## **Development Facilitation Team (DFT) – Review Comments**

**Project No: PR-2019-002089      Date: 00/00/0000      Agenda Item: #10 Zone Atlas Page: K-12**

**Application For: SD-2019-00196-PRELIMINARY/FINAL PLAT (DHO)**

**Project Name:** 239 - 243 Anna Maria Pl SW

SKETCH PLAT OF  
 LOT 19A-P1-A  
 SUNSET FARM SUBDIVISION  
 UNIT 2  
 SITUATE WITHIN  
 PROJECTED SECTION 24, T. 10 N., R. 2 E., N.M.P.M.  
 TOWN OF ATRISCO GRANT  
 CITY OF ALBUQUERQUE  
 BERNALILLO COUNTY, NEW MEXICO  
 JULY 2022

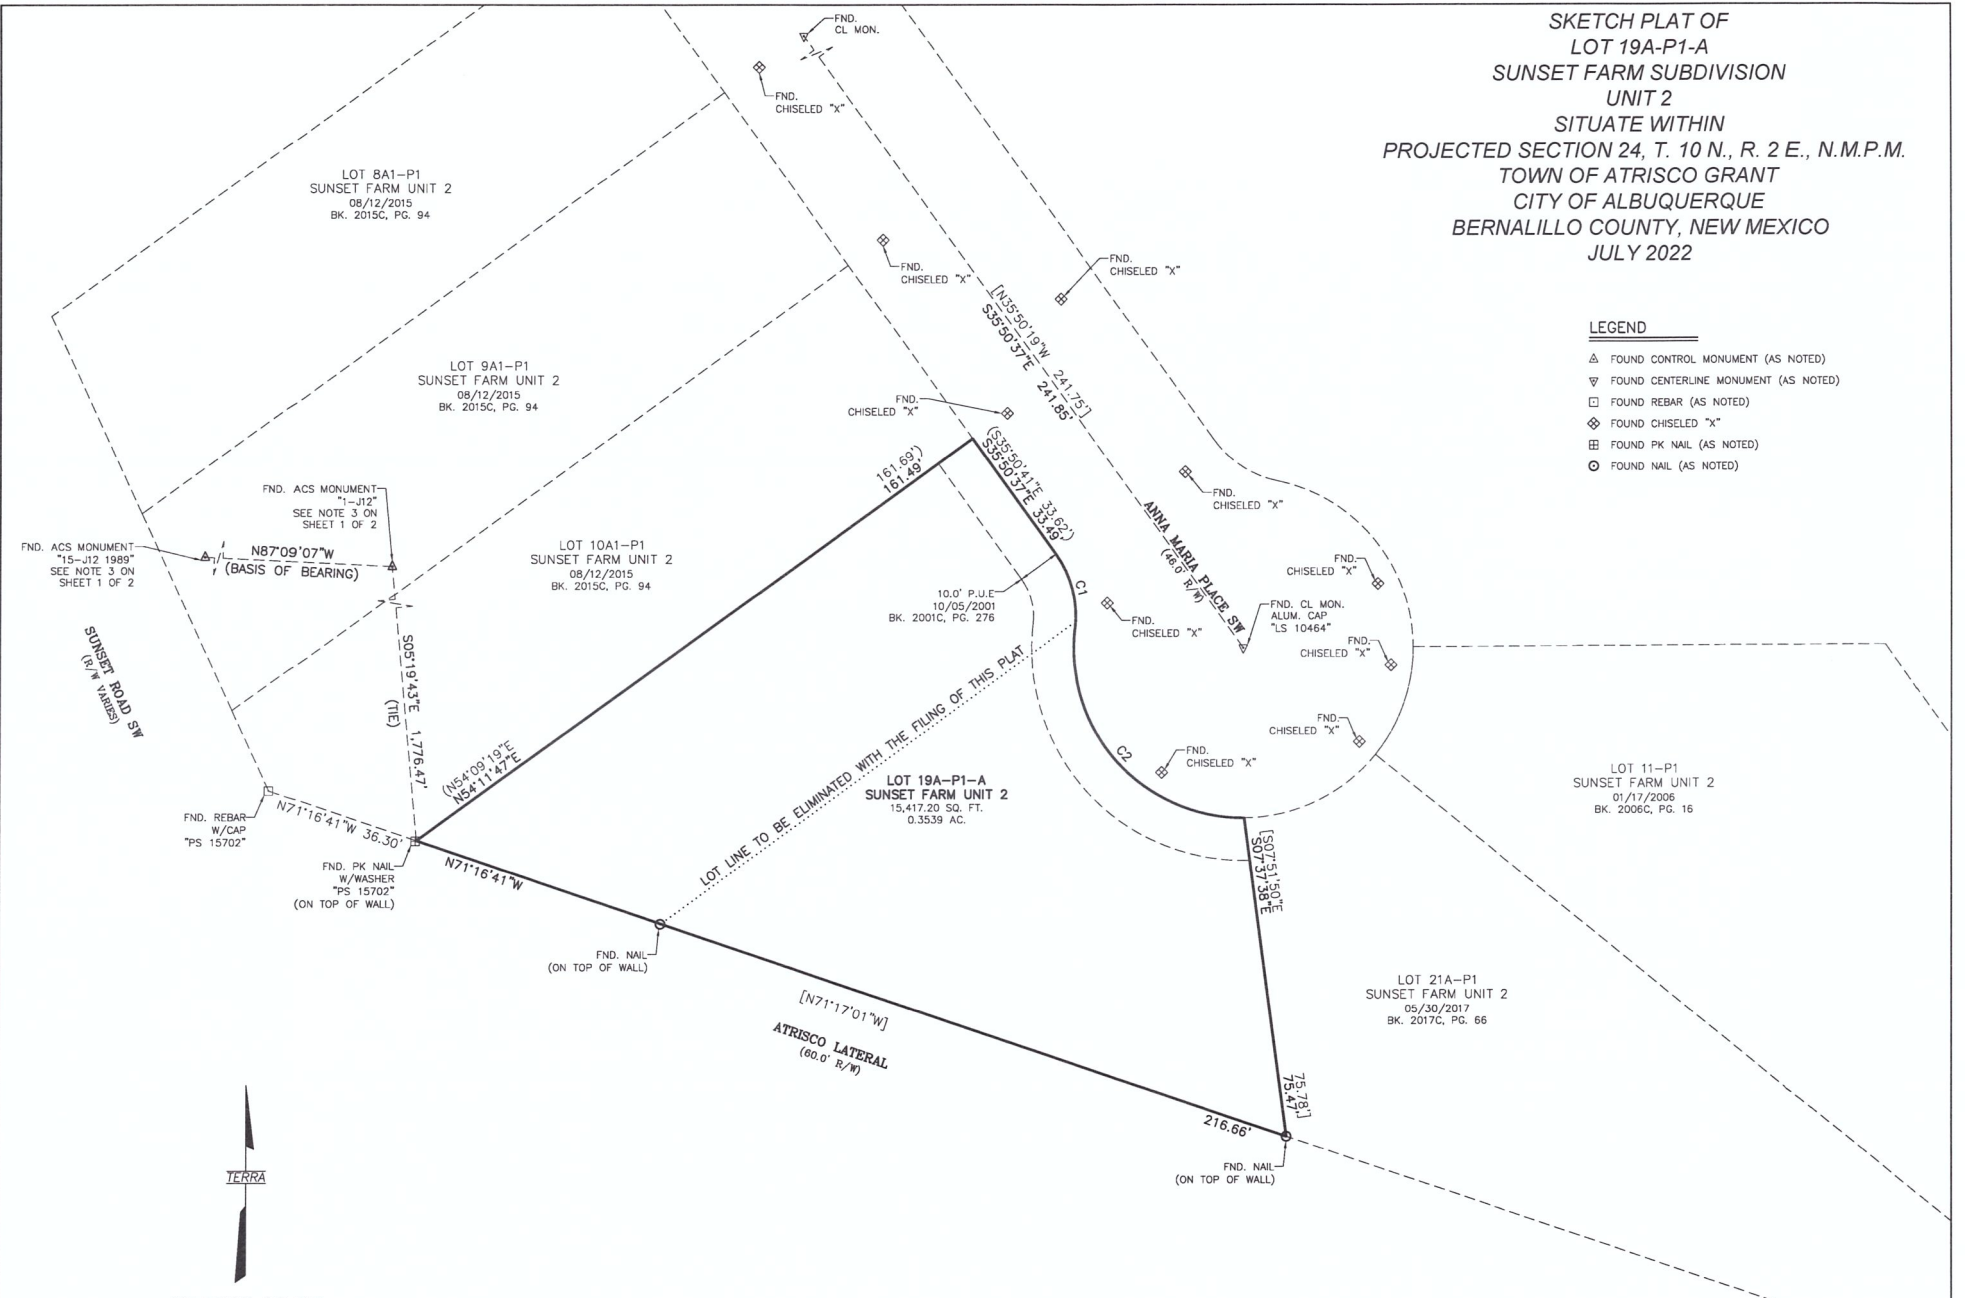
1. Please provide a diagram showing existing sidewalk width along with property line and roadway width. Anna Maria is a local road and 5' sidewalks with a 4-6' landscape buffer are required. If you cannot meet the requirements you may request a determination with a justification letter.

- **\*Please confirm ROW development detail and the compliance of section 7 of the DPM, Table 7.2.29. In regards to Sidewalk width requirements and its landscape buffer.**  
***\*Defer to Transportation for standards.***  
Anna Maria Pl SW is a local street: a 5-foot sidewalk and a 4-6 -foot Landscape Buffer is required.
- Per 6-6(L)(2)(d)(7) of the IDO, the date of the DHO approval shall be recorded on the Final Plat. Therefore, prior to final sign-off of the Final Plat, the date of the DHO approval must be added to the Plat.
- All standards within IDO section 5-4 Subdivision of Land and 5-4(C) Compliance with Zoning Requirements apply to platting actions.
- After DHO approval and final sign off, a recorded copy of the plat must be sent to the Planning Manager-Jay Rodenbeck and [PLNDRS@cabq.gov](mailto:PLNDRS@cabq.gov) (should the Plat be approved by the DHO).
